**KIRKLEES METROPOLITAN COUNCIL
INVESTMENT & REGENERATION SERVICE**

DELEGATED DECISION TO DETERMINE PLANNING APPLICATIONS

Reference No:	2024/62/93632/W
Site Address:	3, Percy Street, Fartown, Huddersfield, HD2 2RX
Description:	Erection of front and rear dormer windows and increase roof height
Recommending Officer:	Lucy Taylor

Officer Report.

Drawing
Existing Elevations

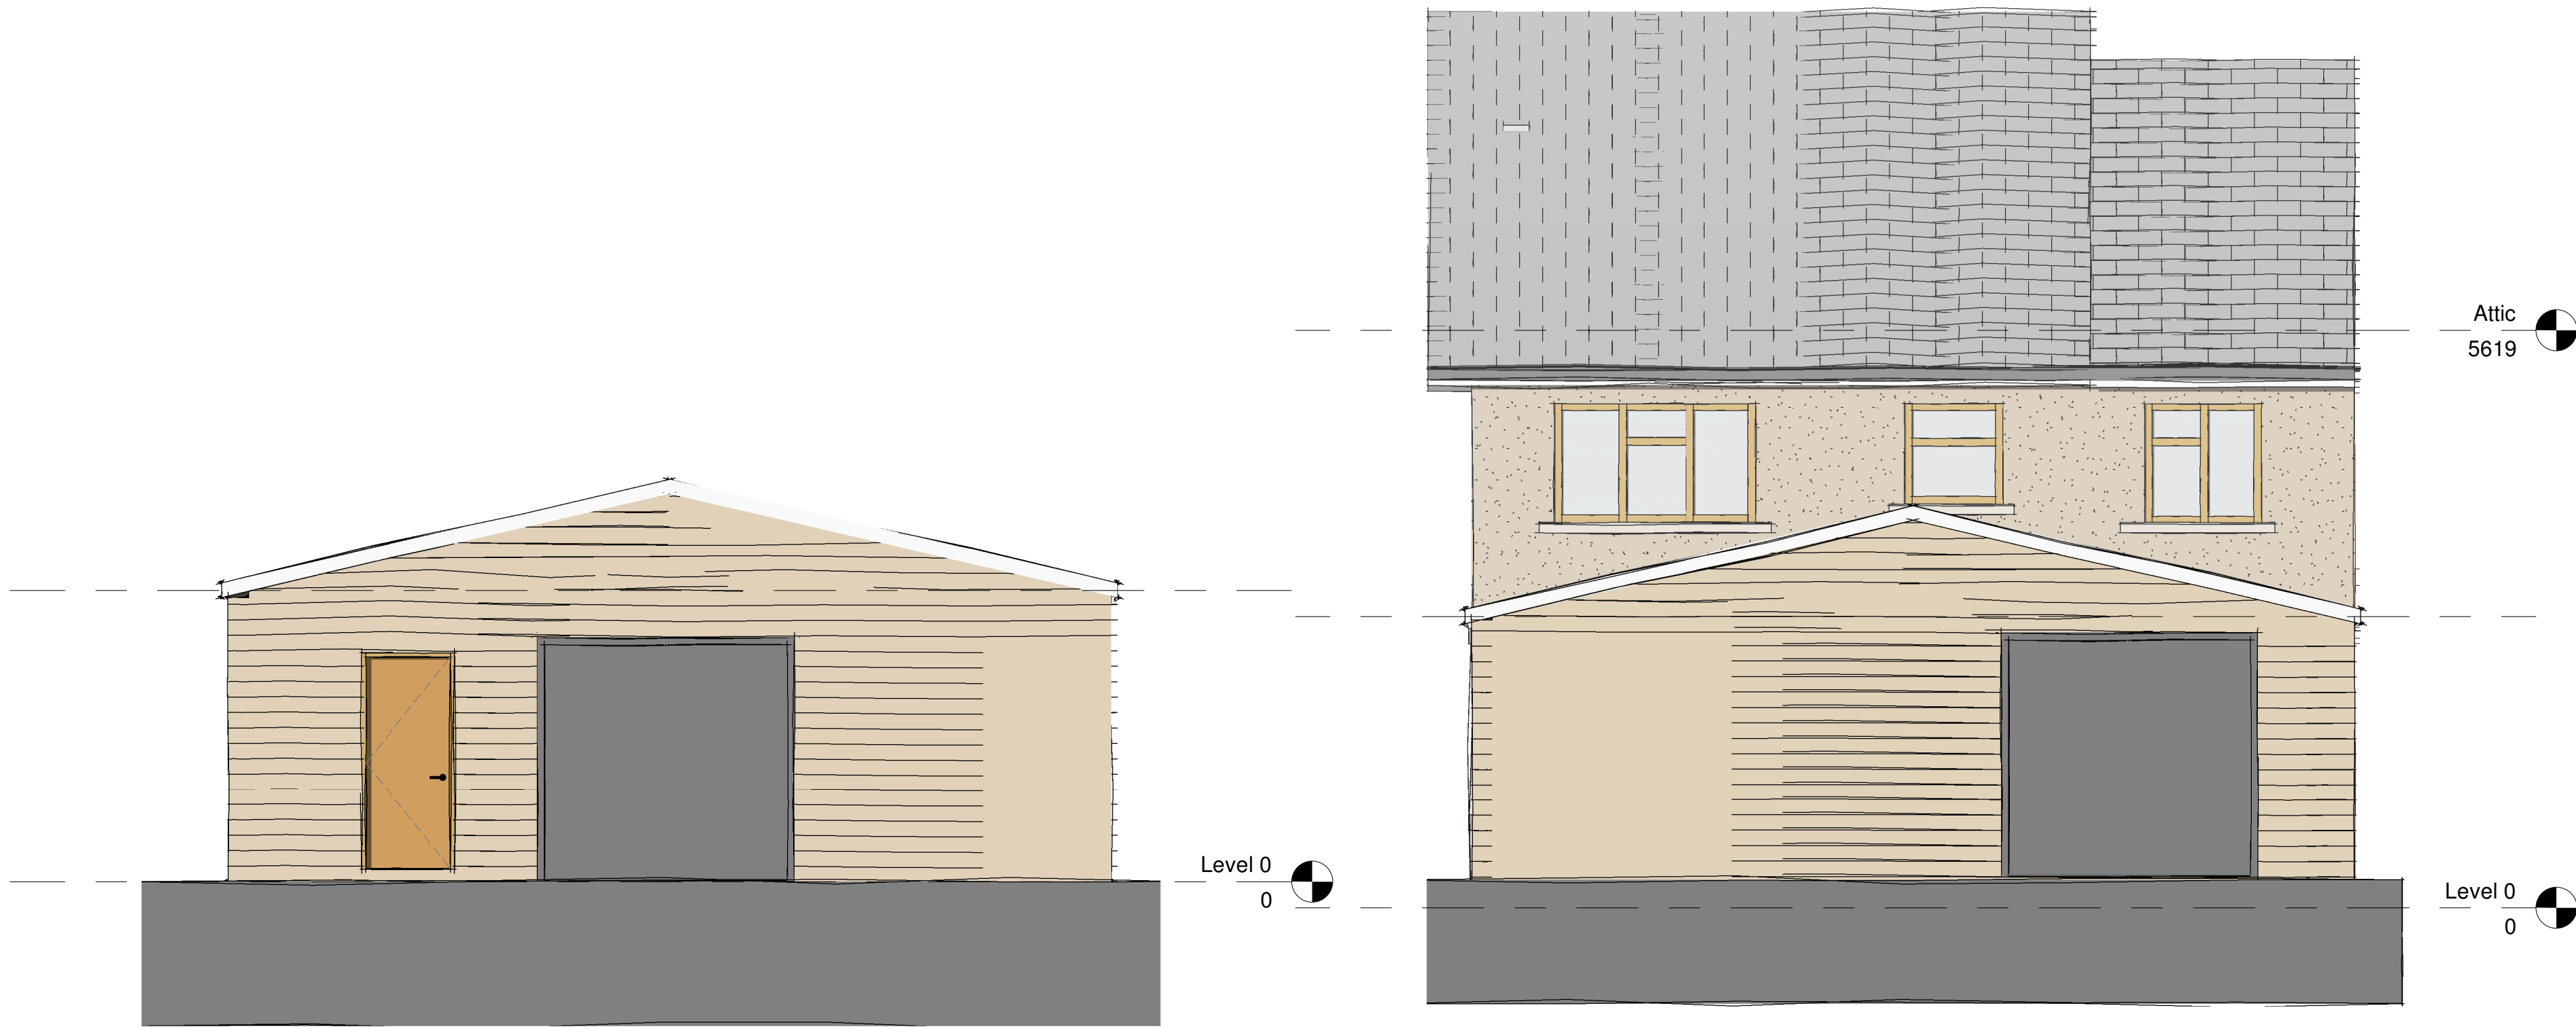
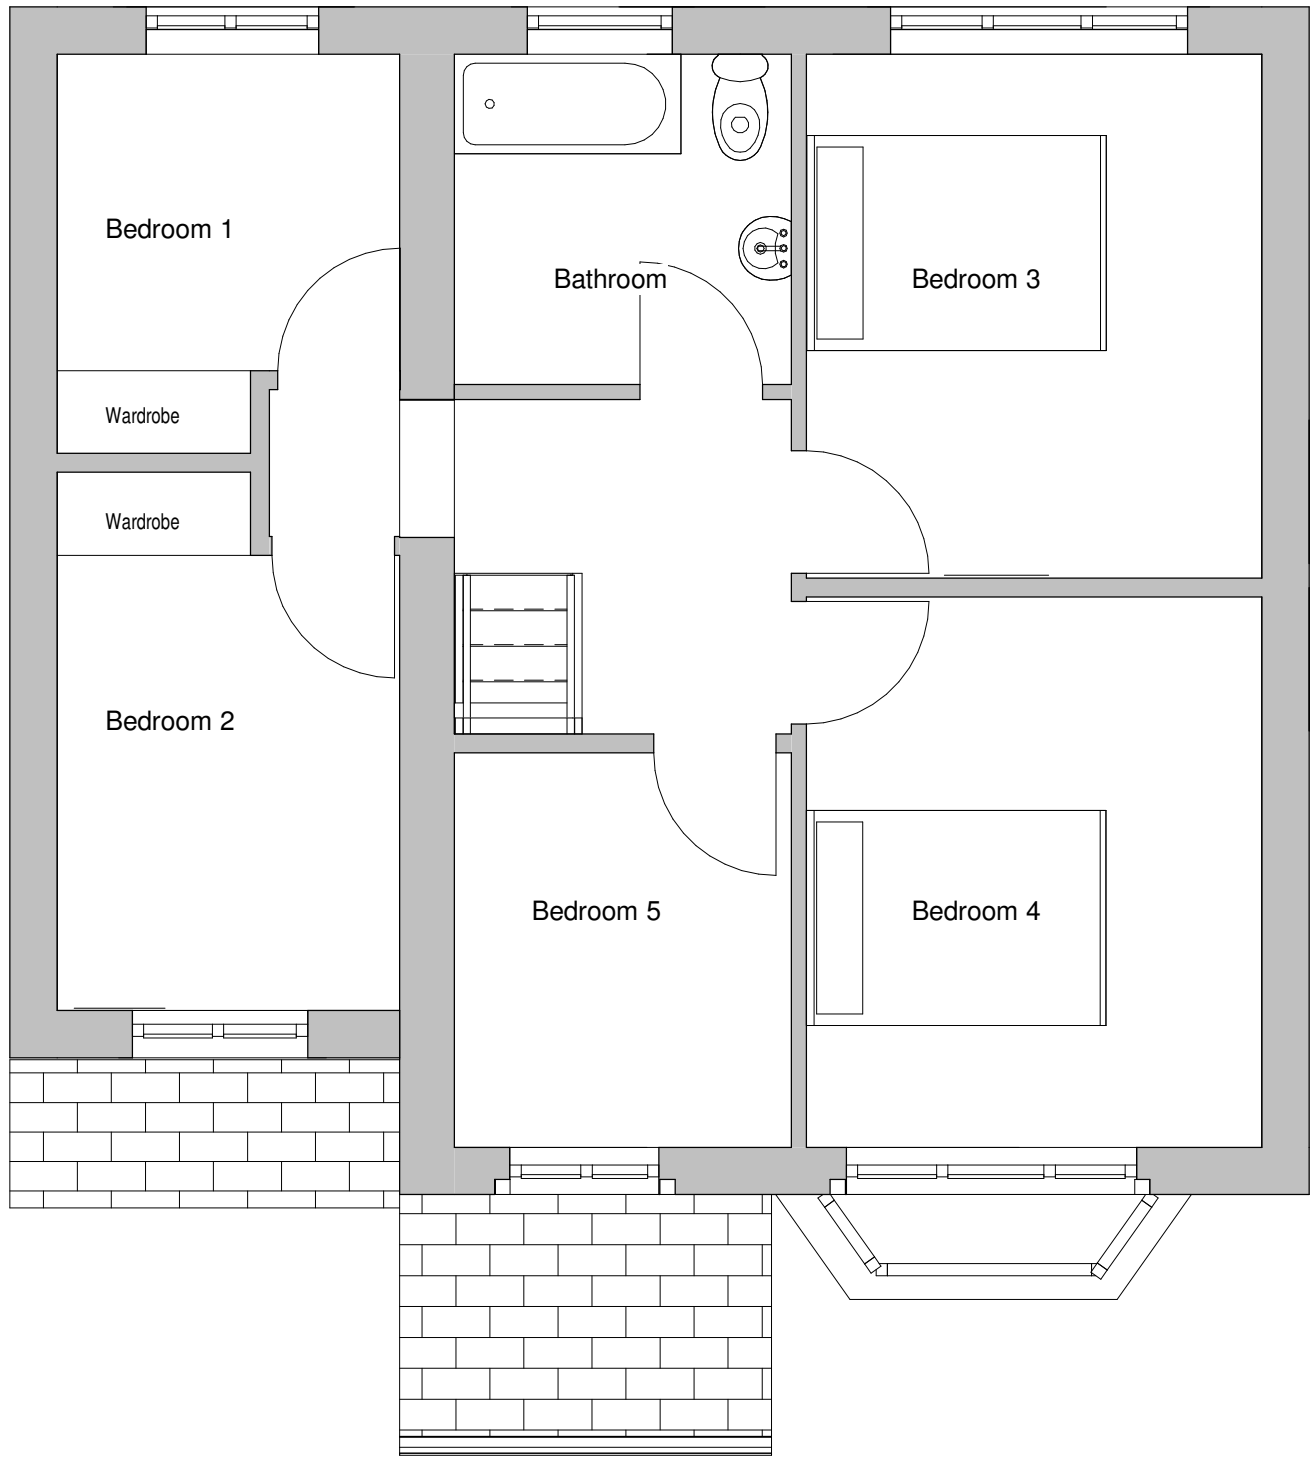
The existing roof above the two-storey side addition will be increased, taking the ridge height of the two-storey side addition to the same as the host dwelling. This increase in height is considered to have a detrimental effect on the overall design of the previously erected two-storey side extension, altering its current subservient appearance / siting to create an extension which would be seen as overtly dominant.

The rear dormer proposed to No. 3 Percy Street would be a box like structure, built across the roof plane of the host dwelling and the previously erected two-storey side extension. Given the size/scale of the proposed rear dormer, as well as its width across both roofs, it is considered that it would result in the building appearing top heavy and cluttered.

Paragraph 5.25 states that *"Ideally, dormers should be located to the rear of a house and should be as small as possible with a substantial area of the original roof retained."* In this instance, the rear dormer would take up a significant extent of the roof plane of the original house, as well as covering some of the rear roof slope of the side extension. Furthermore, the dormer would be set down from the ridge height of the roof by only approximately 0.2 metres.

Whilst officers note that the design of the rear dormer has been altered from that proposed under previous application 2023/93545, this is only very slightly, with the depth and height of the dormer the same as previously proposed and the width of the dormer reduced only by 0.7 metres, from 6.3 metres to 5.6 metres. The proposed rear dormer still goes across the roof plane of both the host dwelling and two-storey side extension and is still only set down from the ridge height of the roof by approximately 0.2 metres.
